Our reference: EF13/2705:DOC16/401196-02:MF
Contact: Matt Fuller (02) 4224 4100

DA 470-11-2003 – MOD 8 – PROPOSED QUARRY BUND
BORAL RESOURCES – DUNMORE QUARRY

I refer to your letter and attached Environmental Assessment (EA) to the Environment Protection Authority (EPA) of 11 August 2016 seeking comment on a proposed modification to DA 470-11-2003 for a proposed bund to be constructed west of the existing Croome Farm quarry operations at Boral Dunmore.

Figure 2: Proposed Modification

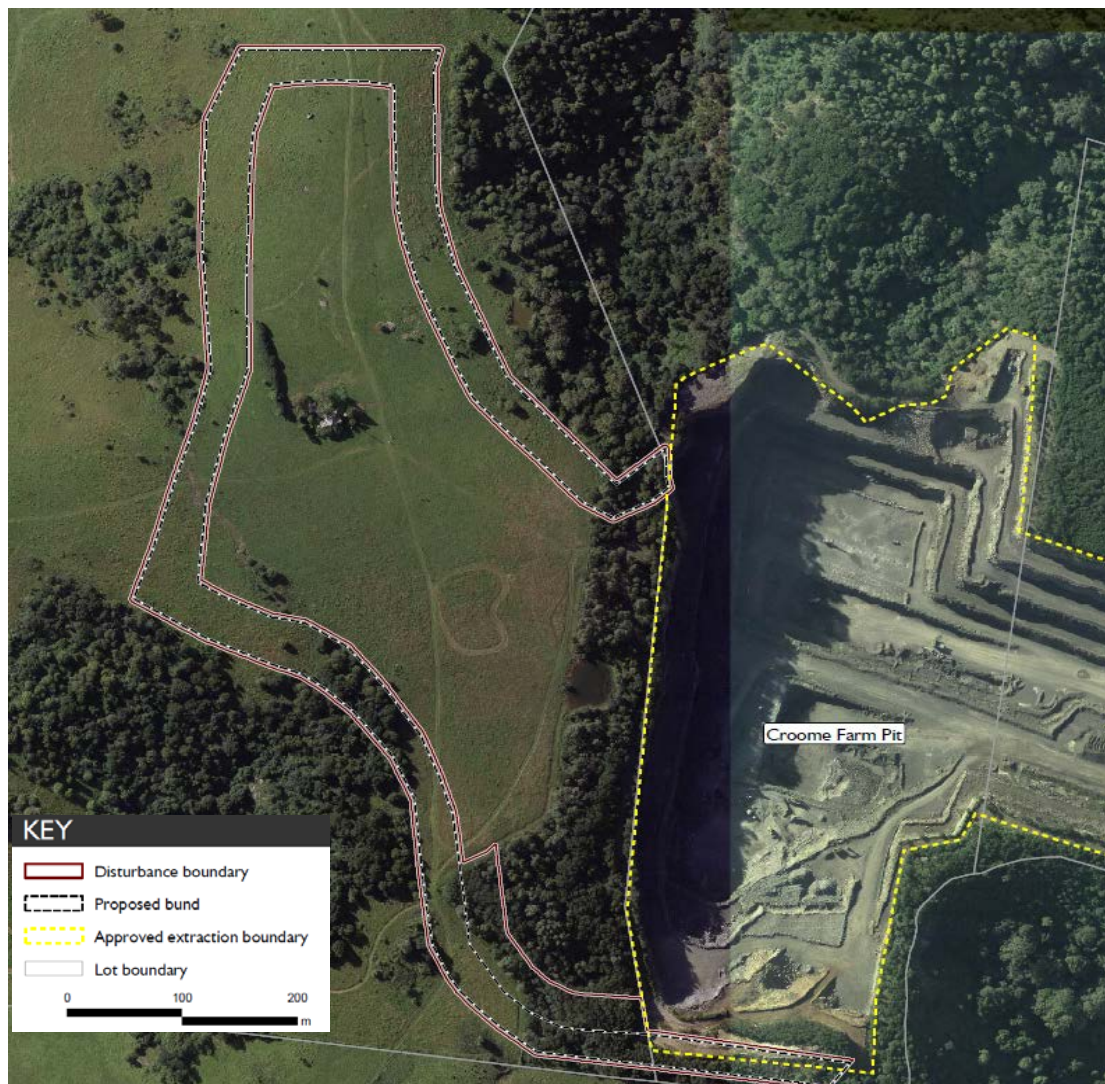
1. The design and size of the bund does not appear to have been clearly justified from a noise and visual management perspective.
 - i. There appears to be no information in the EA on how the bund will provide noise management to residences to the west of the proposed future extraction area (Mod 9), if approved.
 - ii. There appears to be insufficient information in the EA to demonstrate the relationship of the bund to the topography of the land to support its visual management outcome. This includes information on the relative levels (in metres) of the land and bund. This is important in justifying the scale of bund construction, quantity of overburden to be emplaced and extent of any land disturbance. This can

influence factors such as the duration of the project, vehicle activities/equipment type associated with its construction and resulting environmental impacts, including dust and noise.

2. There are risks that the bund will not provide effective visual and noise management in the absence of Mod 9 being assessed and determined. For example, if the bund was constructed as proposed it may need to be modified following future acoustical assessments under Mod 9 and if the final approved extraction area varied from that proposed in this EA. This may result in additional environmental impacts (for example, noise, dust and vegetation disturbance) that could be avoided by a more integrated assessment and determination of the Mod 8 and 9.

4. There appears to be insufficient information in the EA to demonstrate that revegetation (using native plants) will be successful using extracted overburden. Extracted overburden will have less organic matter than soil, and may retain less moisture. Previous revegetation in this area has been challenging to get established. Successful and timely revegetation is important from a dust management perspective as the site is elevated and exposed to frequent strong winds.
